DEVELOPMENT REVIEW BOARD – SPEED MEMO

DRB CASE NO/PROJECT NO: 1002194

**RE: Lots 6 & 7, Sunport Townhomes/p&f**

Project Name: **SUNPORT TOWNHOMES**

# PLAT OF LOTS 6-A AND 7-A SUNPORT TOWNHOMES

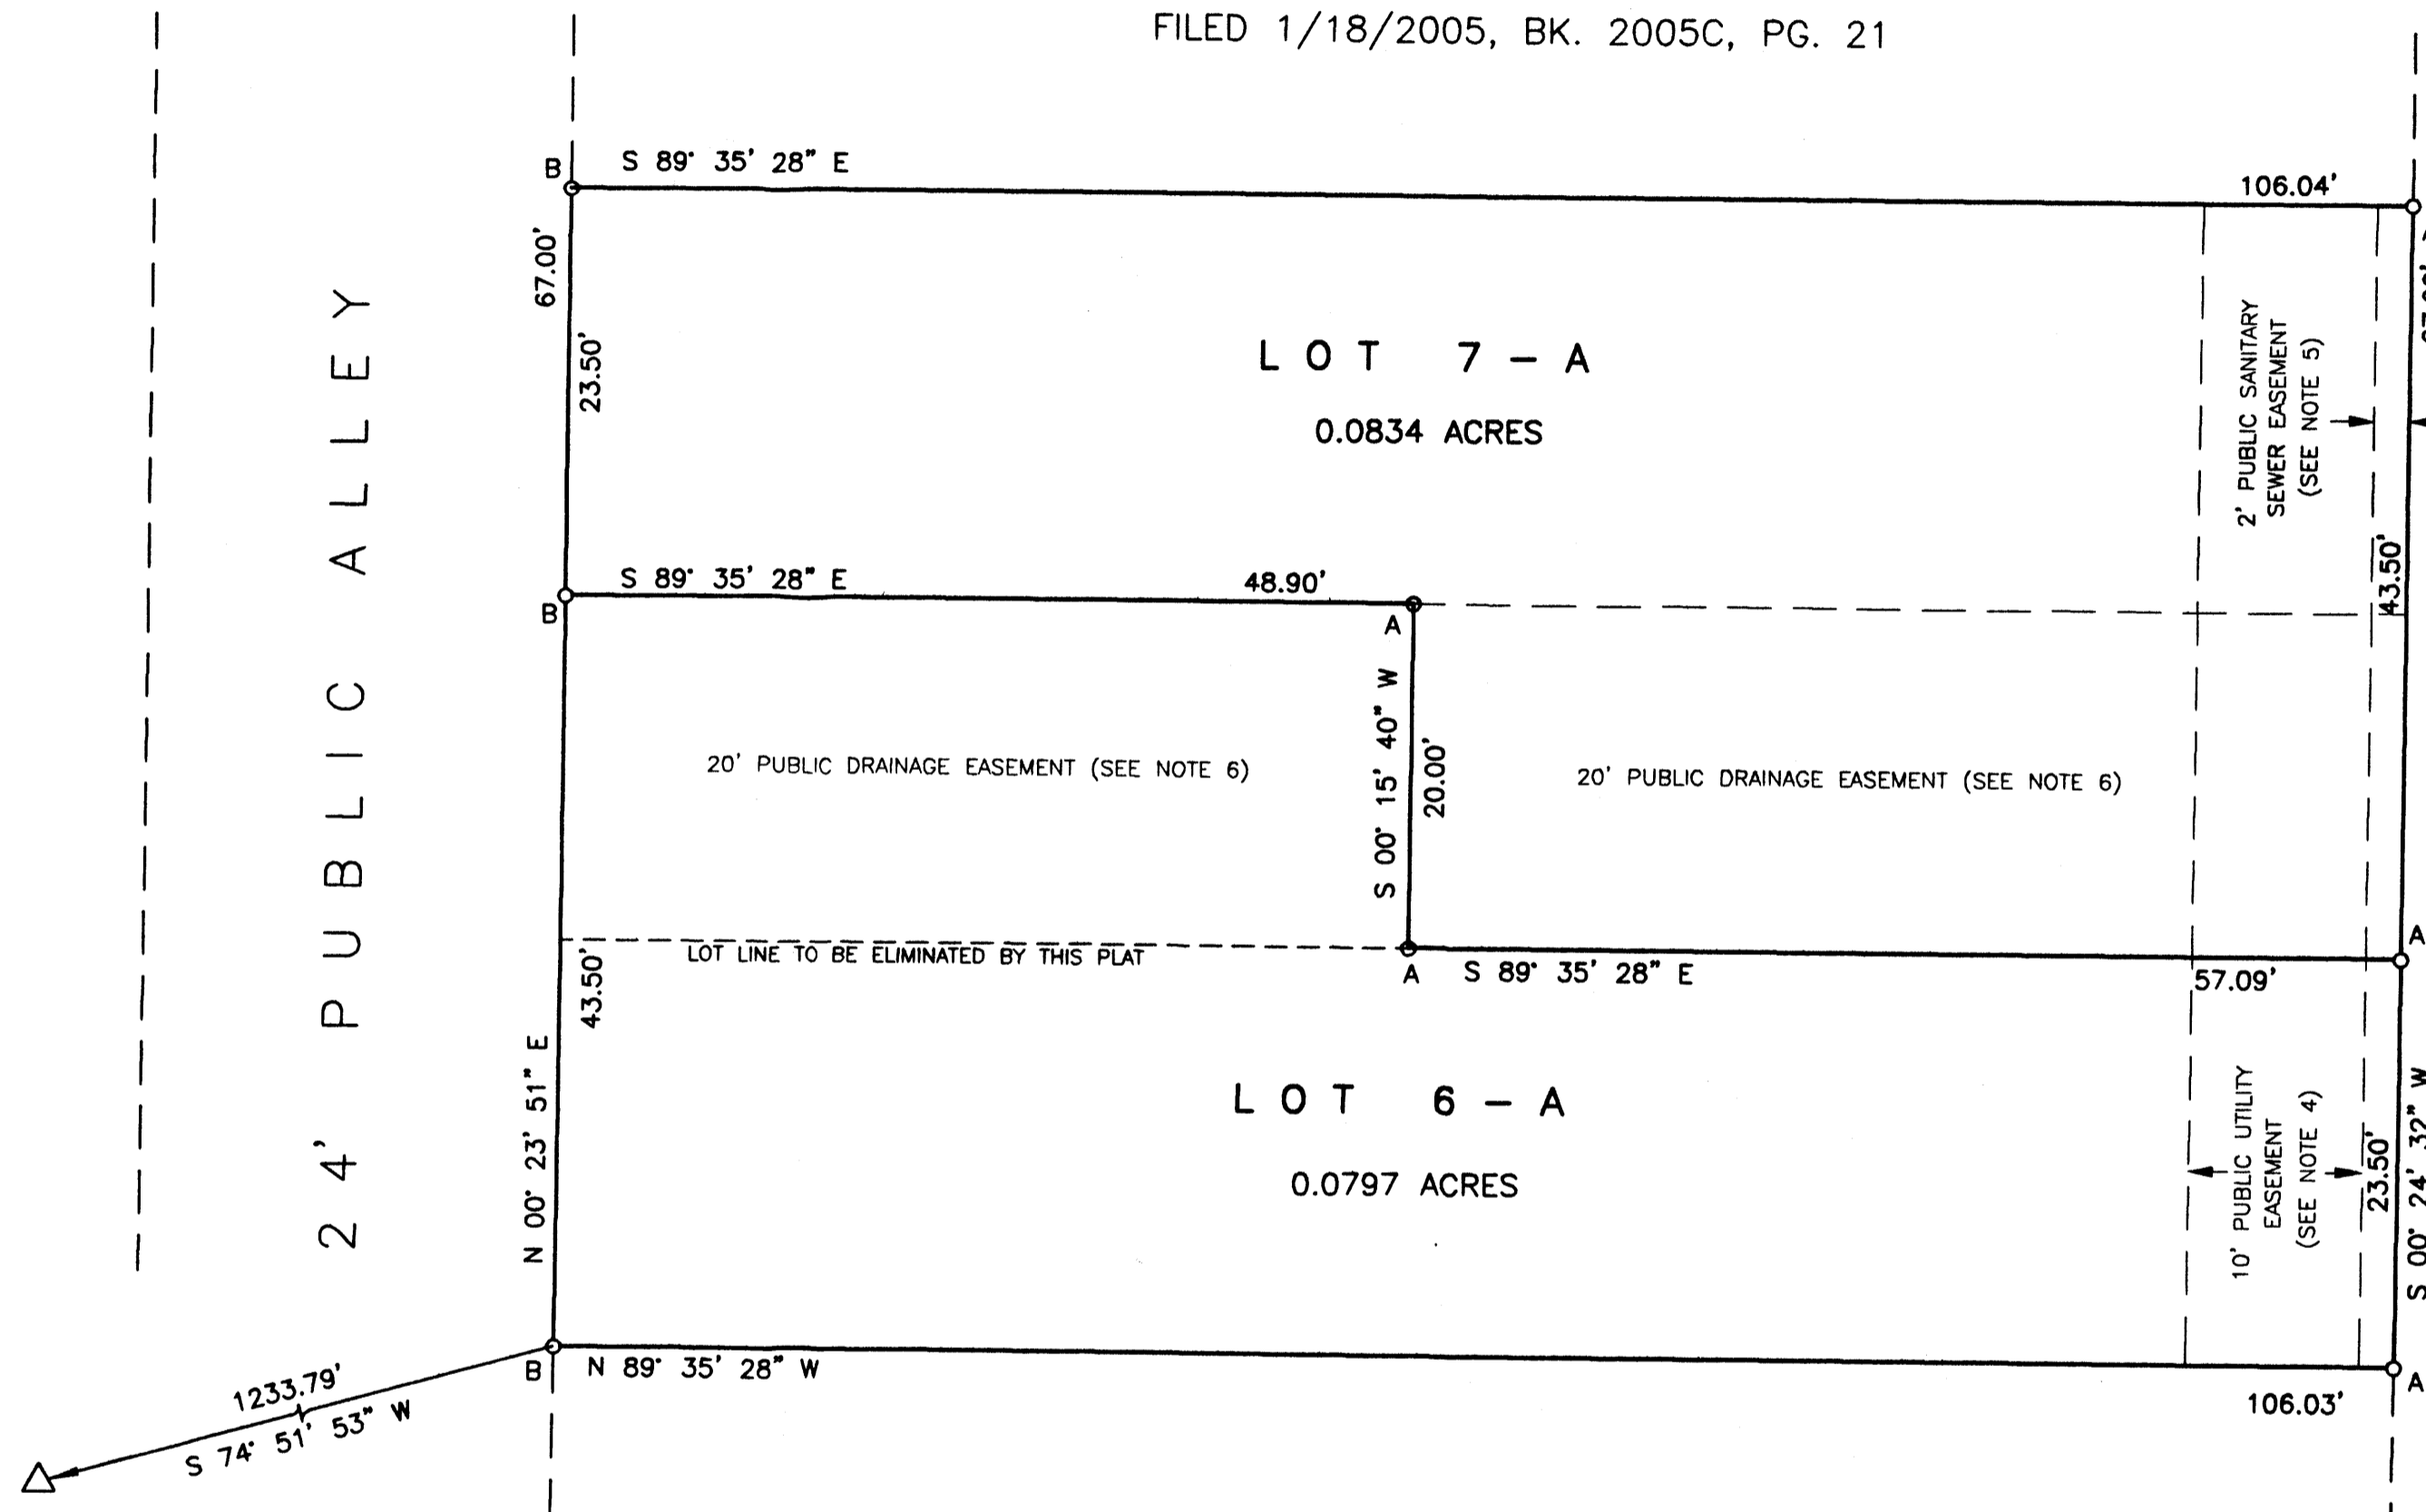
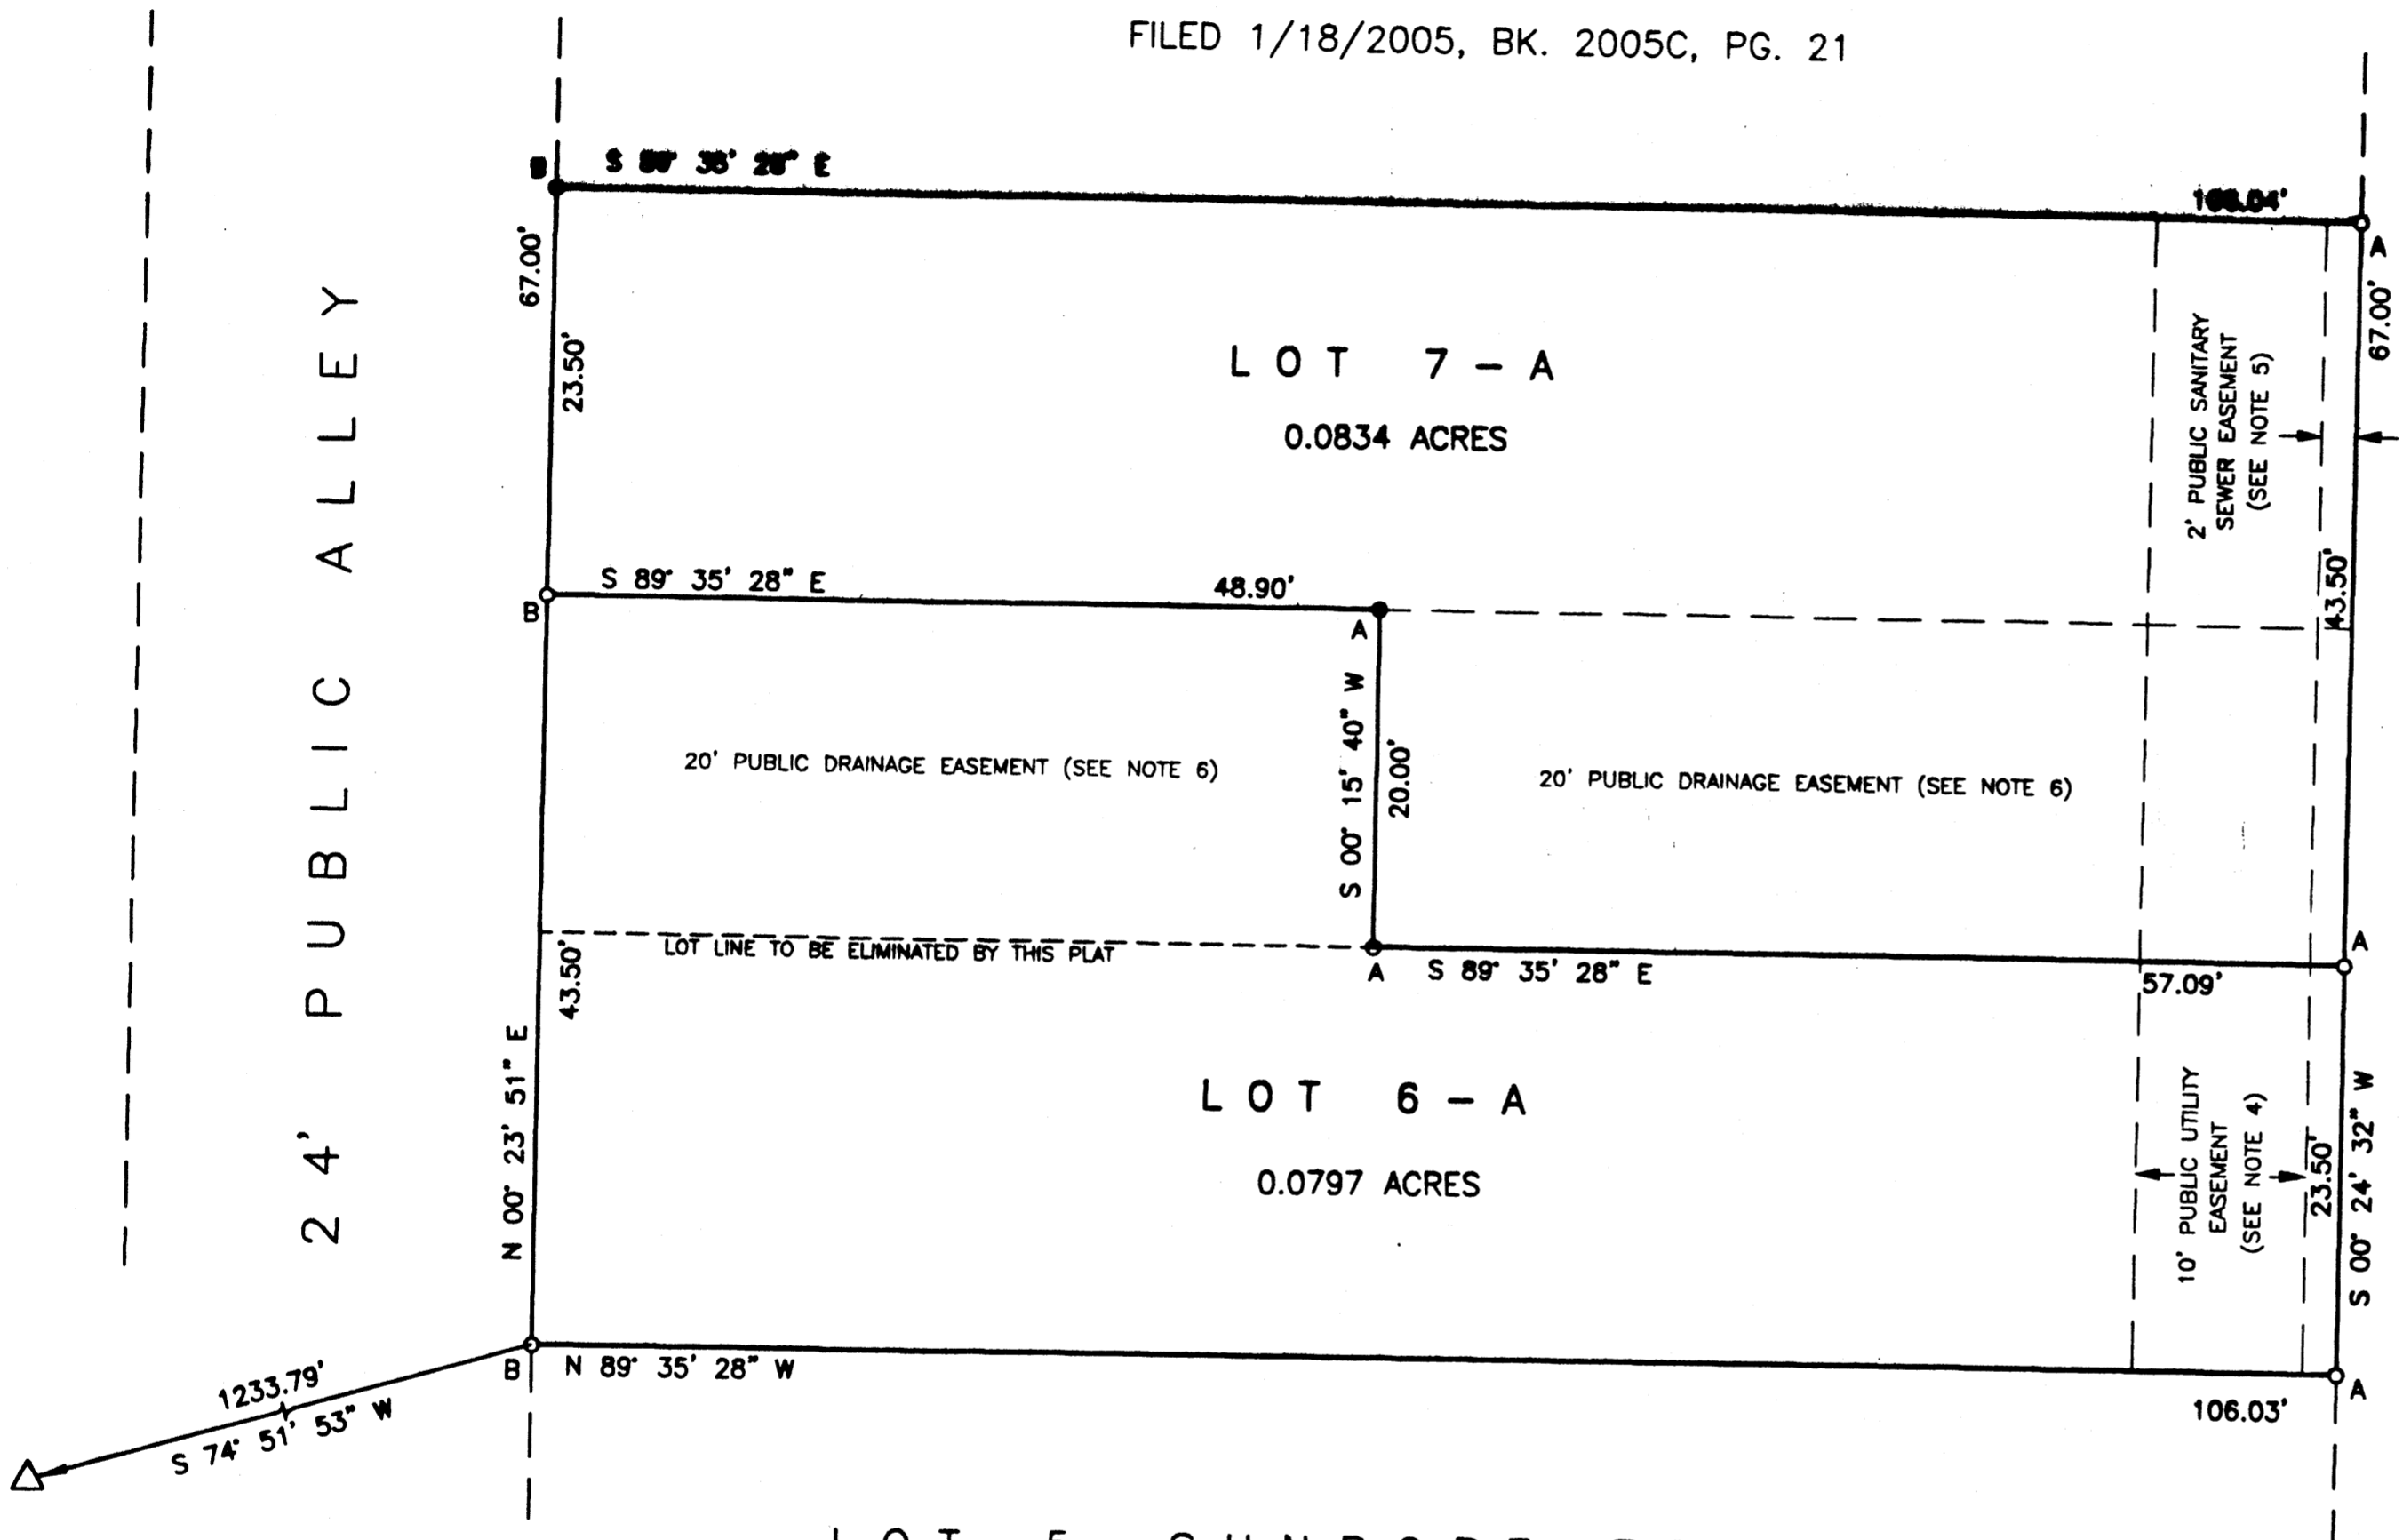
The subject application requires that the plat must contain the following language regarding the installation of solar collectors developed within an area for which DRB approval is sought::

Section 14-14-4-7(B) "No property within the area of requested final action shall at any time be subject to a deed restriction, covenant, or building agreement prohibiting solar collectors from being installed on buildings or erected on the lots or parcels within the area of proposed plat. The foregoing requirement shall be a condition to approval of this plat or site development plan for Subdivision."

Planning will take delegation for the solar collector language on the plat and to record the plat.
